TfNSW Reference: SYD19/01502/05

Council Reference: SSD 10395

NOTICE OF EXHIBITION OF EIS FOR WESTERN SYDNEY ENERGY & RESOURCE CENTRE – 339 WALLGROVE ROAD, EASTERN CREEK

Reference is made to the Department; correspondence dated 1 October 2020, requesting comments from Transport for NSW (TfNSW) on the Environmental Impact Statement on the abovementioned application.

Figure 10: Wallgrove Road / Austral Bricks Road – Gazcorp Industrial Estate 2021 layout

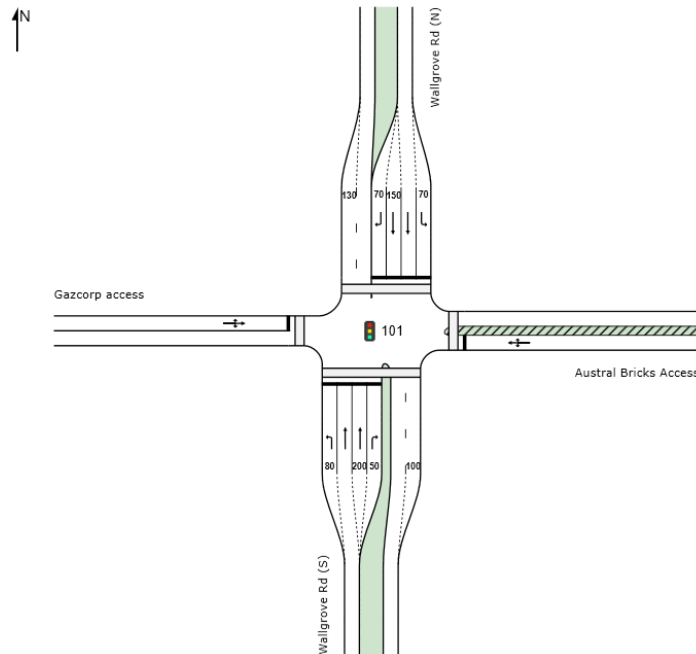
- There is concern with the lack of storage near the access point in the event queueing occurs. Any queueing is expected to have a significant impact on the nearby signals.

- Due to the large impact of heavy vehicles that will use the signalised intersection of Austral Bricks Road and Wallgrove Road, TfNSW require two lanes on Austral Bricks Road on approach to Wallgrove Road to be included in the design to ensure the intersection does not fail. This request was noted in pre- DA advice. Amended plans and appropriate modelling should be submitted to TfNSW for review.
